Submission No.			27	
Organisation Name or Name of Submitter			Brendan Heneghan (88 Parkmore Drive)	
Item No.	Section Ref.	Page No.	Observation Statement	TII Response
Ref: Metro planning application no 314724, 25 November 2022				
1	Letter	1	<p>A lot of people get off at Charlemont no doubt headed for the metro. They are holding up the tram bound for Bray crossing the railway line to get to the stairs. And there's people coming up the stairs slowing them down. Someone has got the wheels of his case stuck in the track.</p> <p>The lady announces a slight delay. I'm told that there's persistent problems with turning the Luas that finish at Charlemont and because all the passengers have to get out, they are stopped longer at the station too. However we move off a minute later.</p>	<p>The Luas stations are designed as a shared space between pedestrians and trams, hence the designated pedestrian crossing between the Charlemont Stop Luas platforms. The interaction between pedestrians and trams will be managed the same as for any other Luas stop.</p> <p>The stairs referred to have been sized to accommodate the combined predicted passenger flows for Luas to Metro, and Metro to Luas. The lift

CHARLEMONT STATION

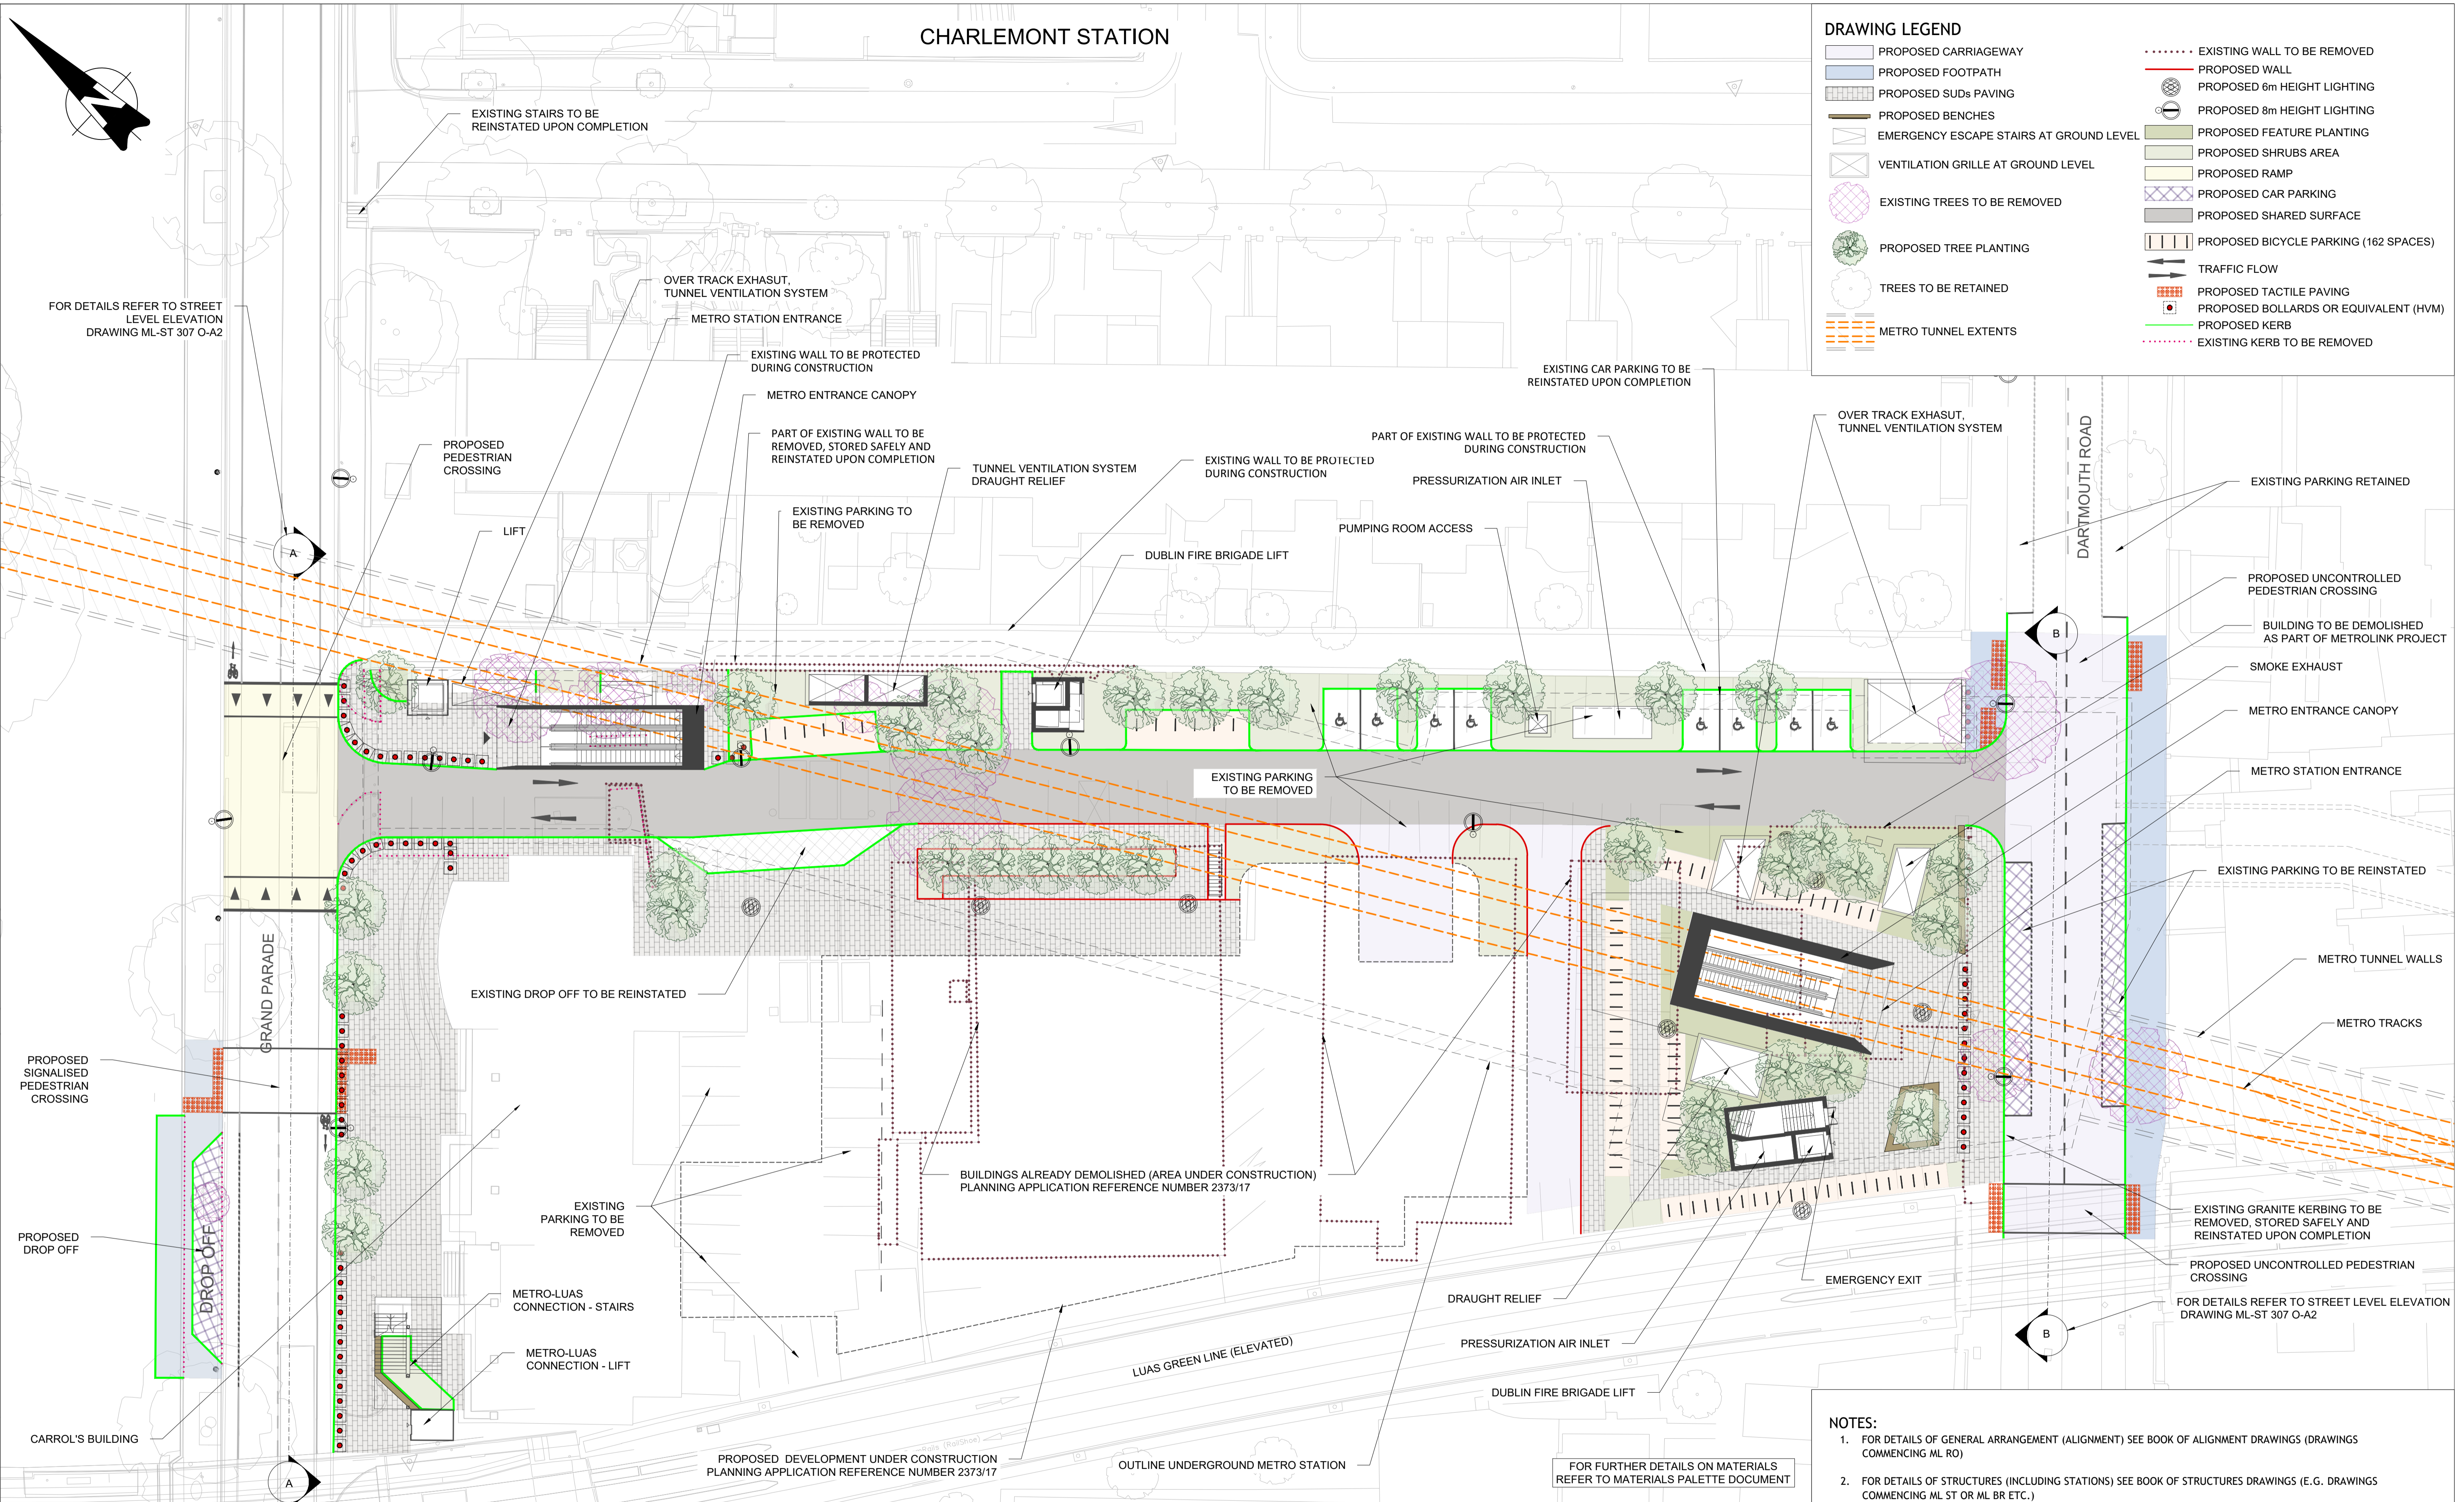
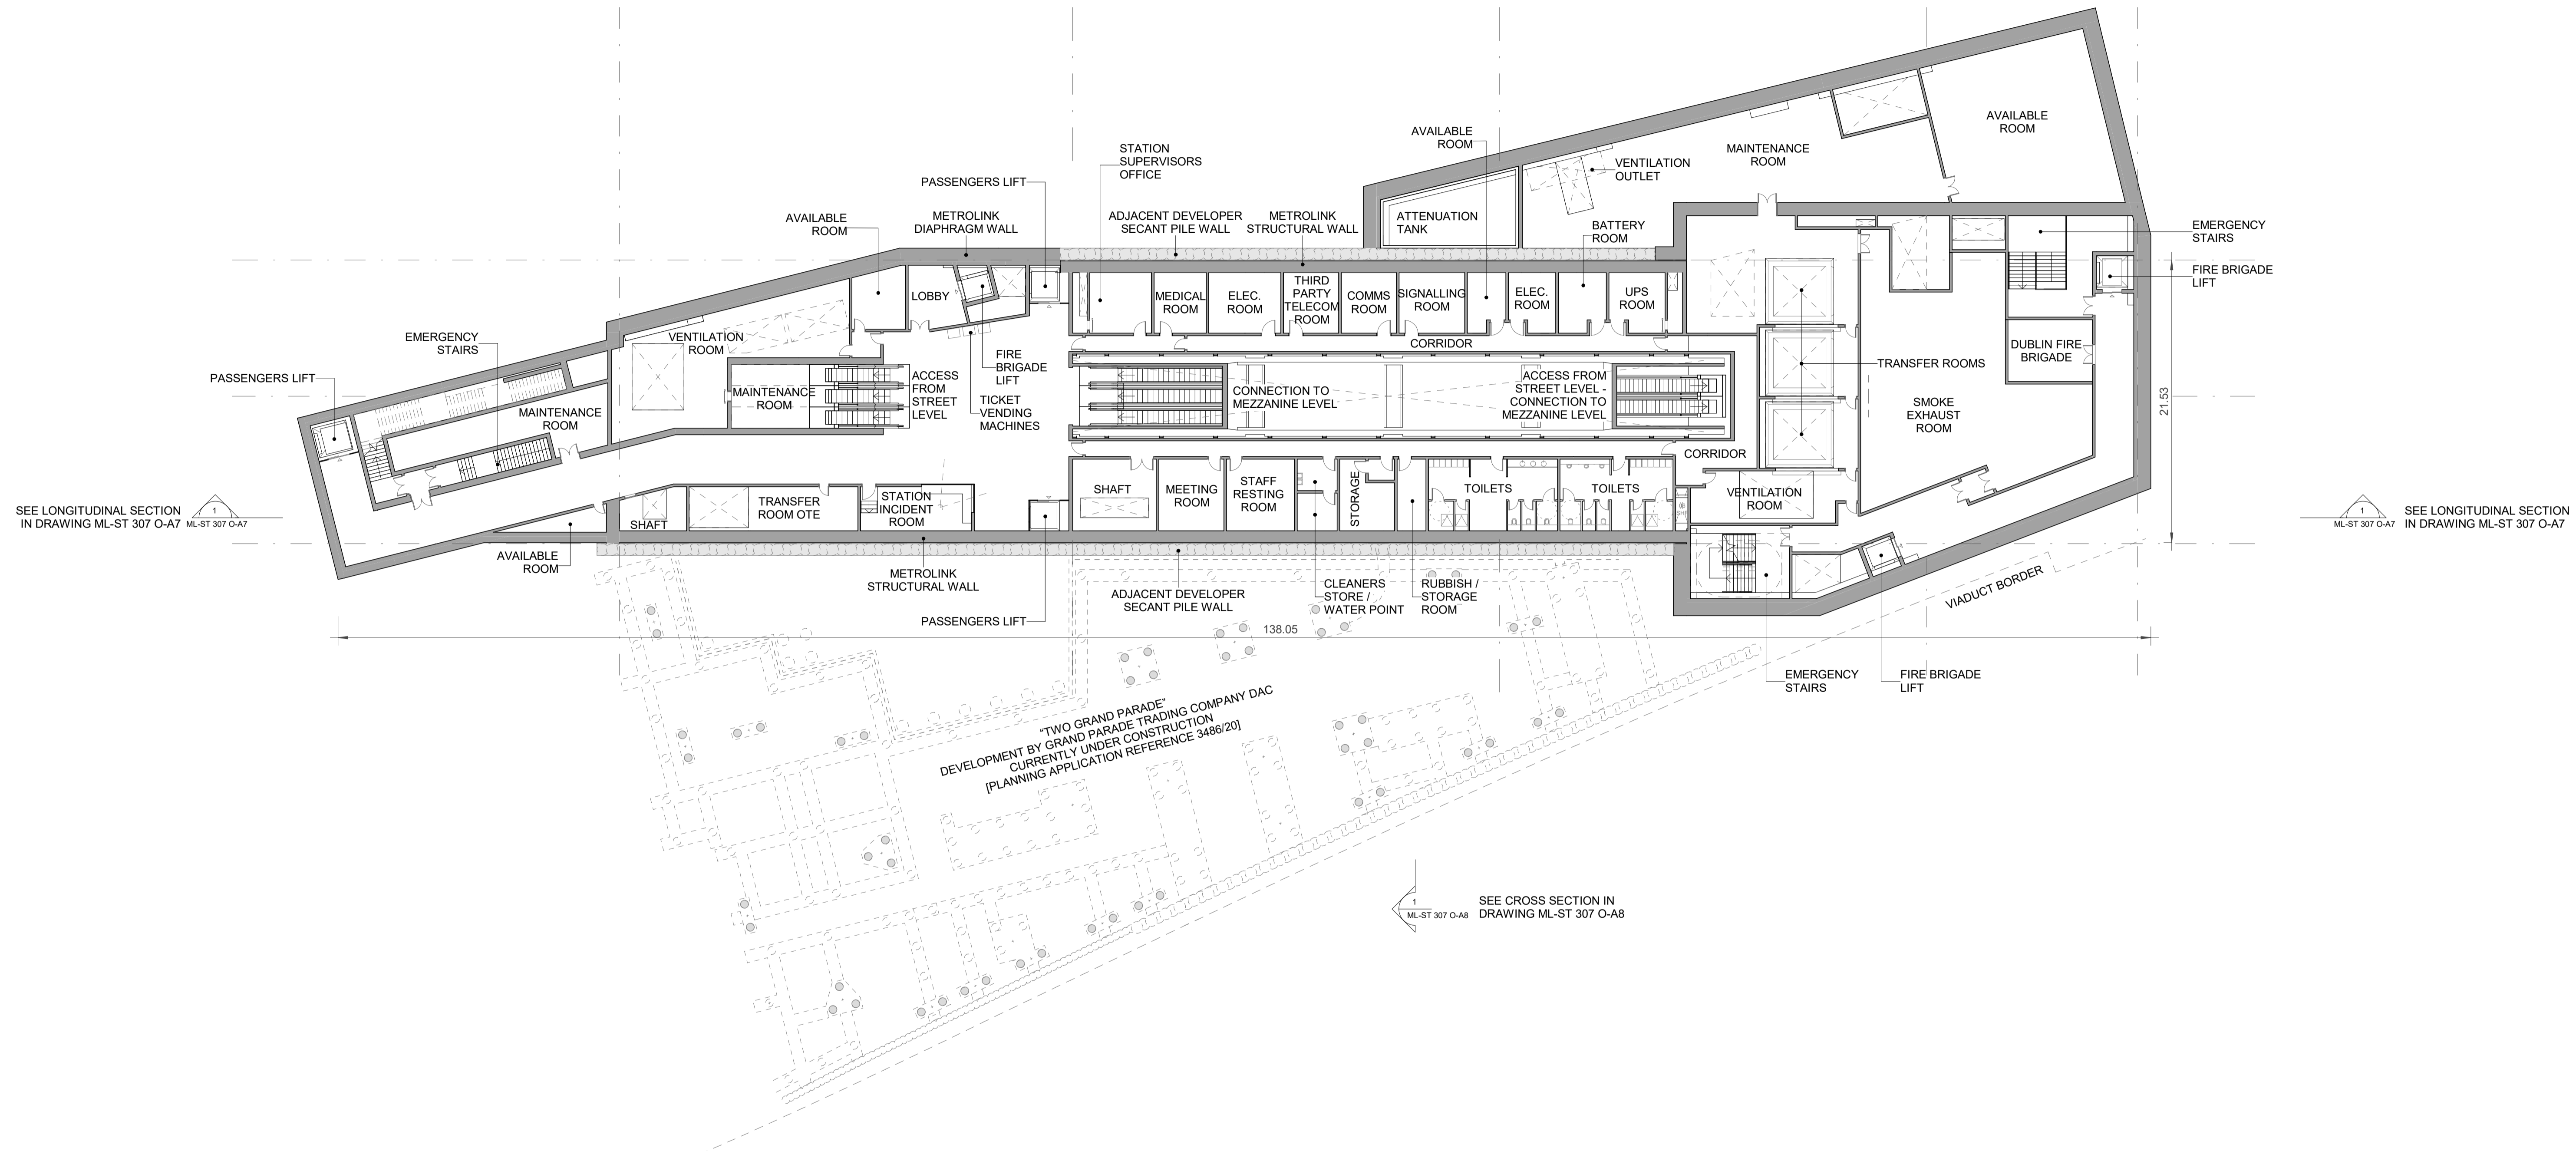
2	Letter	2	<p>On our previous holiday to Lanzarote, we made the mistake of getting off the Luas at Charlemont and transferring to the metro at that point. The metro had just opened. We had massive problems getting the cases down the stairs. Some guy coming up the stairs barged into the missus, even though the signs all say keep to the left. I ended up having to go back up to fetch her case. Not great to have to leave it there as it was a bit of an obstruction. There was a big queue for the lift. I can't get why they didn't put in escalators. Any why didn't they have the metro directly under the Luas with a bank of lifts and escalators. We have to find another way to get to the airport for the pre-Christmas trip.</p> <p>And the return was even worse. Lugging the cases full of the souvenirs for the grandkids up seven flights. That stairs is a nightmare. And when we reached the platform everyone was blocking the platform at the top of the stairs. Took all the benefit out of the holiday. It's like that awful transfer at 168th St Manhattan when you get off the A train from JFK and want to get the 1 to the Bronx.</p>	<p>As noted by response (1) above, the stairs should not be used by passengers carrying luggage of a size not suitable for stairs, and the stairs and lift have been sized for predicted passenger flows, as indicated in Chapter 6 (MetroLink Operations and Maintenance, section 6.4.1), with a lift capacity of 10 passengers.</p> <p>Chapter 6 (MetroLink Operations and Maintenance) indicates that the operation strategy of the proposed Project is driven by the forecasted passenger demand. As such, the peak passenger demand profiles for each station have informed the layout and sizing of platforms and stations to ensure safe and comfortable movements of all users. In recognition of the higher footfall anticipated at this station, two stations entrances are proposed. Additionally, three escalators will be provided at the northern entrance between the station and concourse levels, reflecting the higher footfall predicted with the connection to the Luas line. As presented in Appendix A9.2-B Traffic and Transport Assessment- Charlemont Station, pedestrian modelling of the station indicates that the design has sufficient capacity to accommodate the pedestrian demand generated at the Charlemont MetroLink station.</p> <p>Within the constraints of the site it is not possible to fit escalators in linking ground level to the Luas, and nor would it be feasible to economically place a station beneath the existing Luas that met the MetroLink operational requirements and architectural vision for the Project. It is also highly likely the demolition of buildings would be required around the Luas if such an option was developed and it would not be possible to provide the quality of station entrances that has been achieved for the proposed Charlemont Station.</p>
